Re: Grandview Reserve Filing No. 1

This firm represents the Upper Black Squirrel Creek Ground Water Management District (the “UBSC District”), a formed and operating ground water management district with the powers enumerated in the Colorado Ground Water Management Act, C.R.S. § 37-90-101 *et seq.* The UBSC District and its water quality expert have reviewed Grandview Reserve Filing No. 1 and provide the following comments:

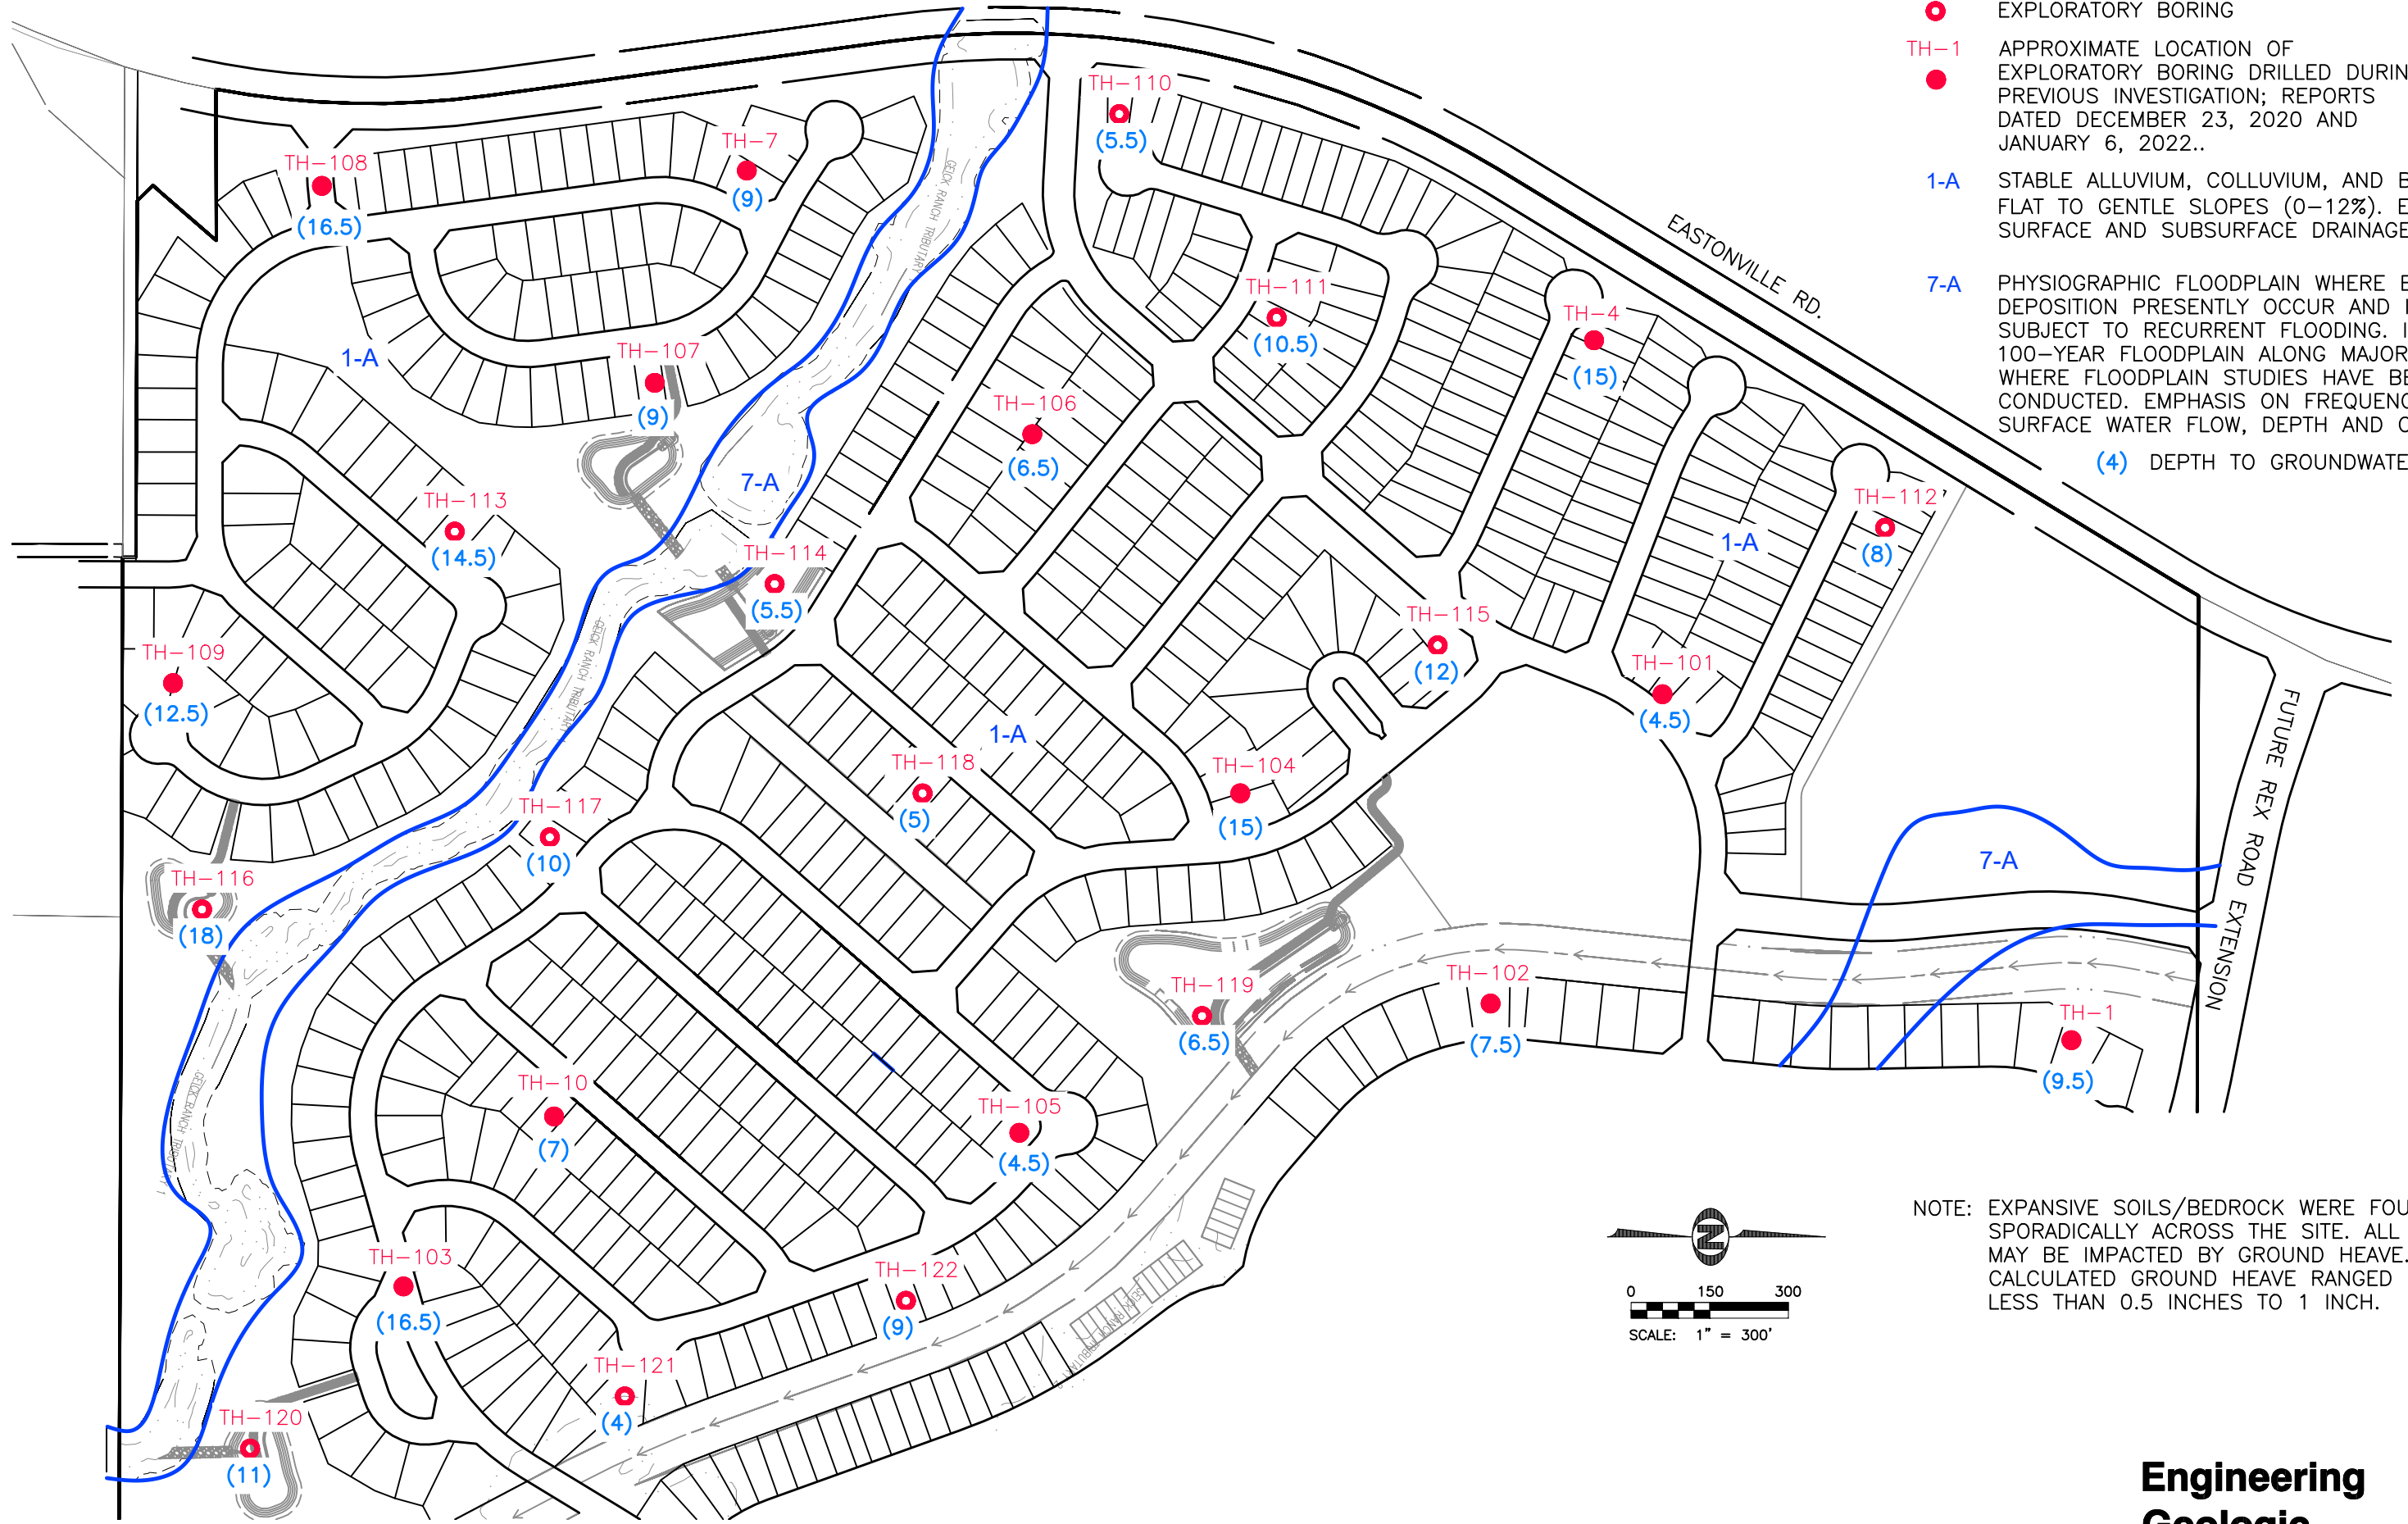
Shallow groundwater exists throughout the area underlying the Grandview Reserve Filing No. 1 and may cause geotechnical problems related to unwanted inflow to basements and detention ponds as well as erosion of detention pond side slopes. In addition, due to this shallow groundwater, structures developed in Grandview Reserve Filing No. 1 may need underdrains to capture and drain water that would otherwise flood those structures. Any underdrains will require a large capacity well permit from the Ground Water Commission and those well permits will require a replacement plan in compliance with Ground Water Commission Designated Basin Rule 5.6. Any such replacement plan should meet the requirements of Designated Basin Rule 5.6 by replacing any groundwater collected in any of the underdrains that is discharged to the surface and for the evaporation and ET associated with the exposure of groundwater caused by the underdrain.
